Our ref: Hastings Secondary College Port Macquarie Campus Upgrade Modification 2
(SSD-11920082-Mod-2)

19 December 2022

Subject: Request for Additional Information

Materiality of the PCYC building

4662
DA3011

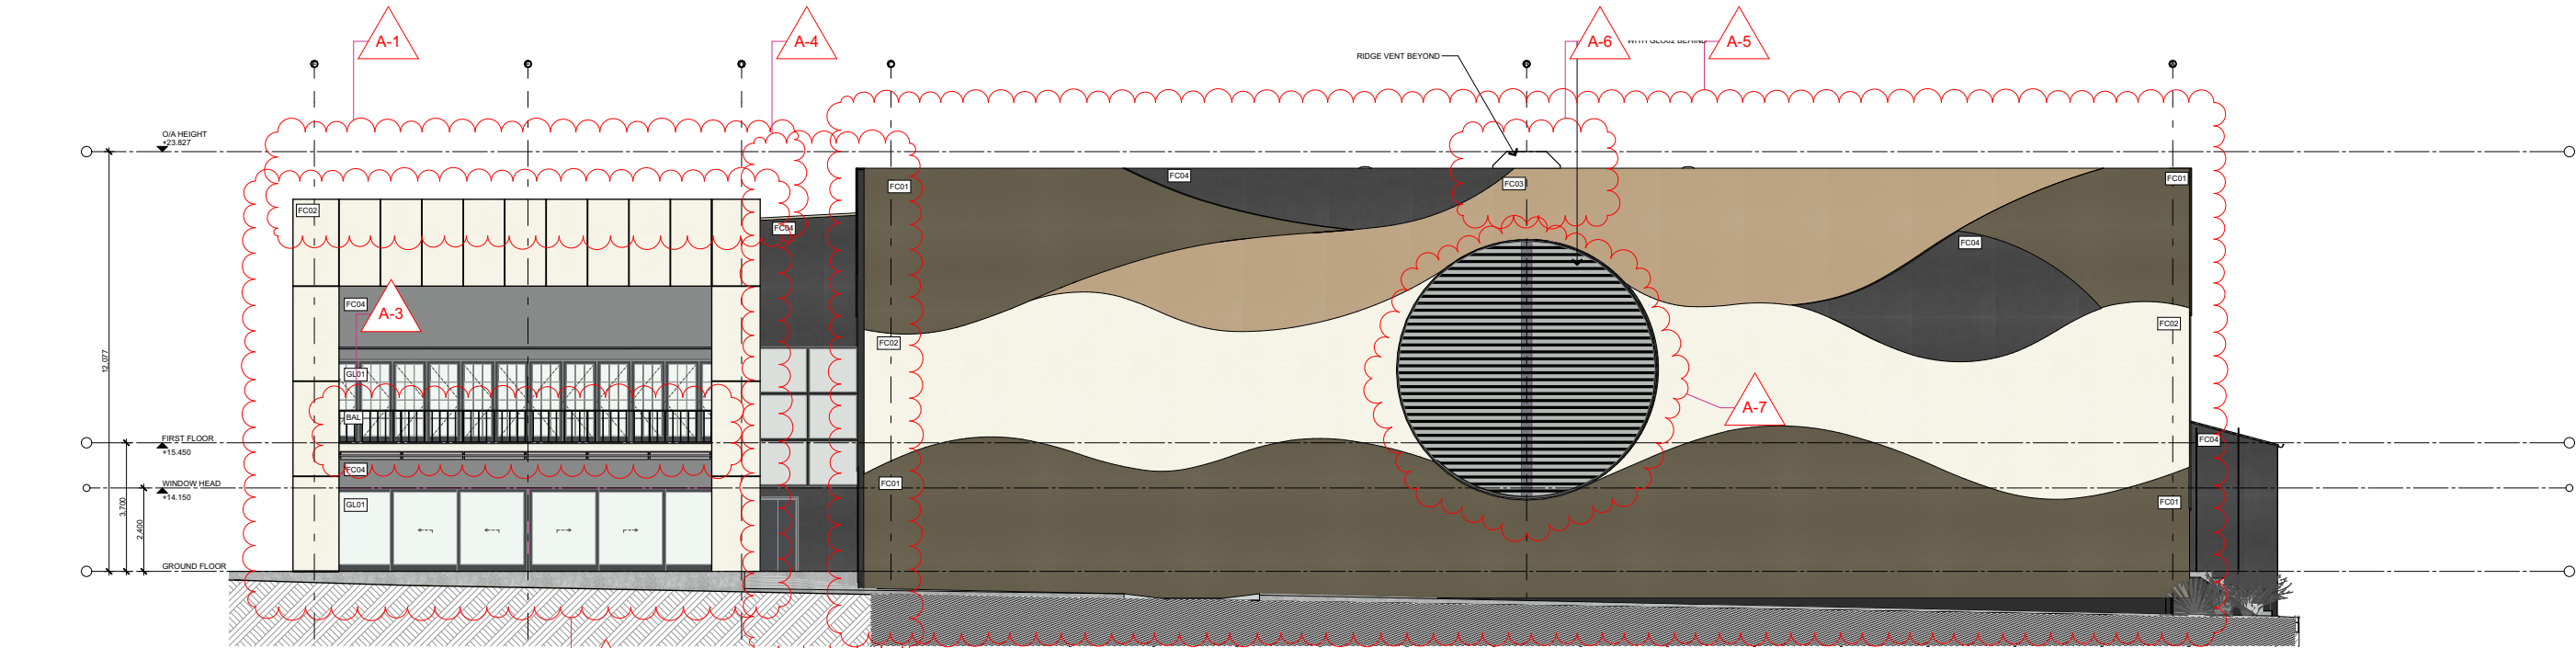
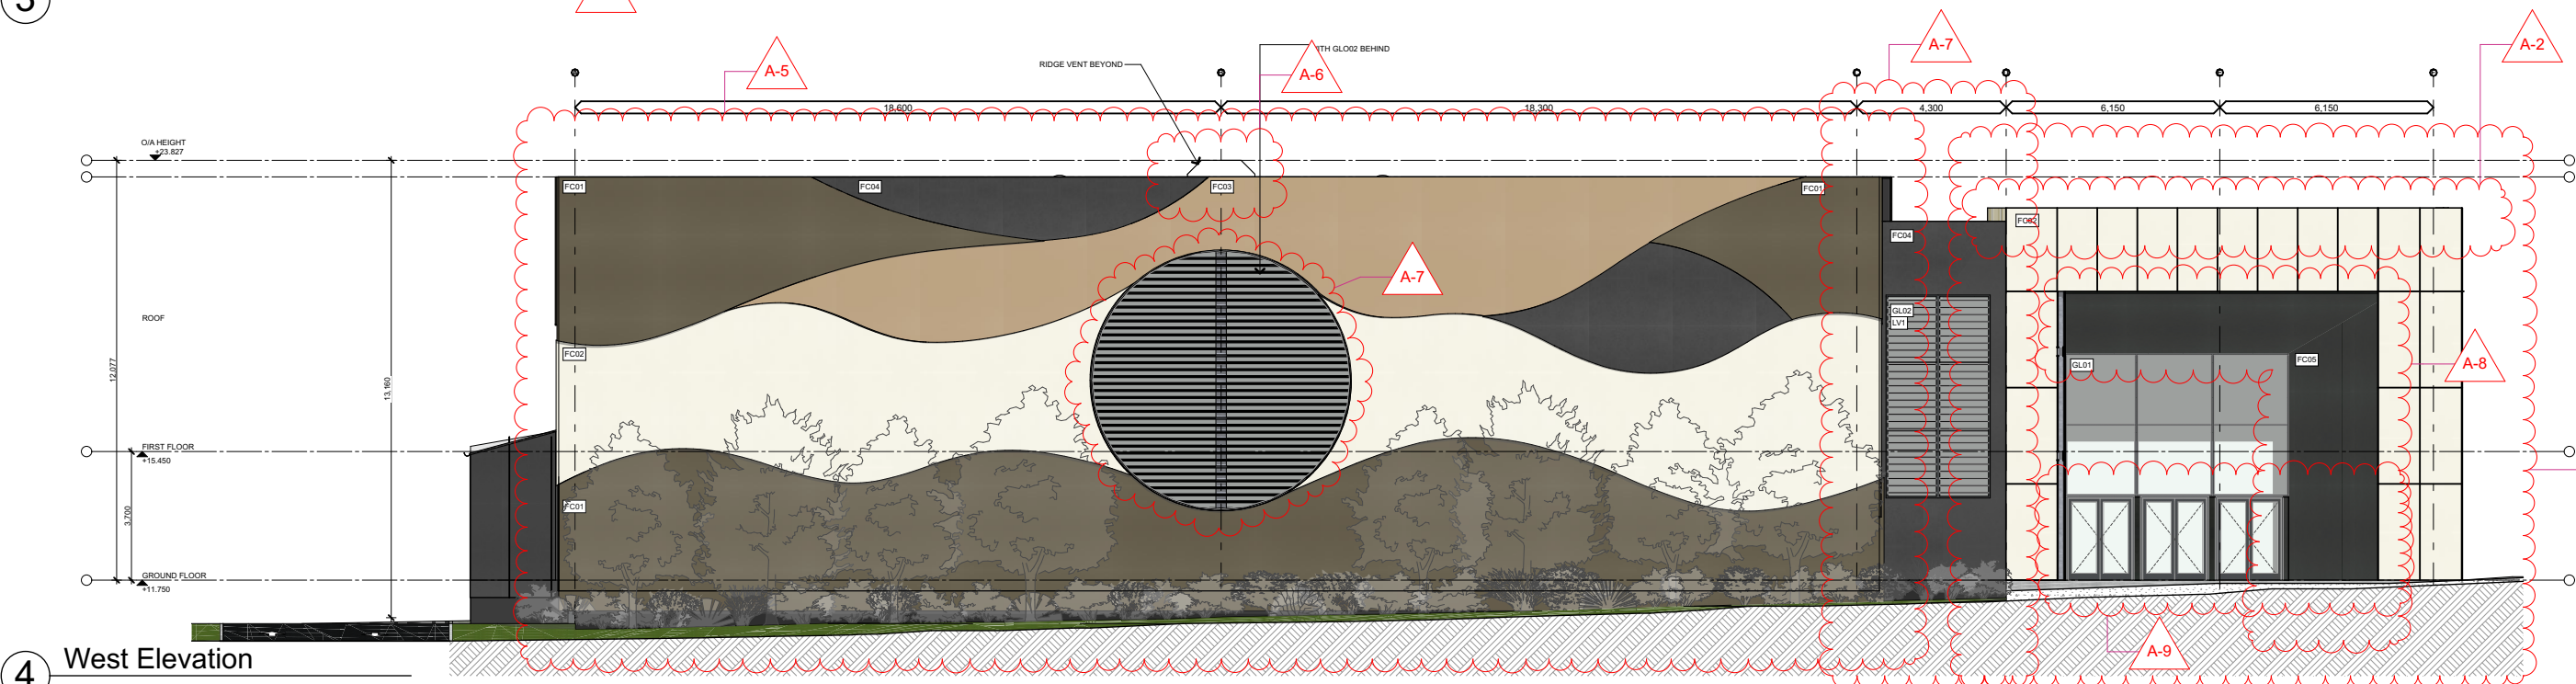
- The proposed amended materials of the PCYC façades do not reflect the key design principles identified in the Architectural Design Statement provided as part of the EIS.
- Cladding would not be complimentary to the scale and texture of the existing and heritage connection of the site. The proposed materials do align with the existing heritage framework of the 1960s campus consisting of an established language of two storey, face brick forms with low pitched metal roofs. The Statement of Heritage Impact provided as part of the EIS suggests that the proposed use of bricks (similarly toned to the existing bricks on site), off form concrete and steel roofing would respond to the predominant existing materials used at the site.
- The fibre cement panelling would exacerbate the visual perception of bulkiness as opposed to the approved brickwork.

Revised architectural plans are to be provided addressing the above points.
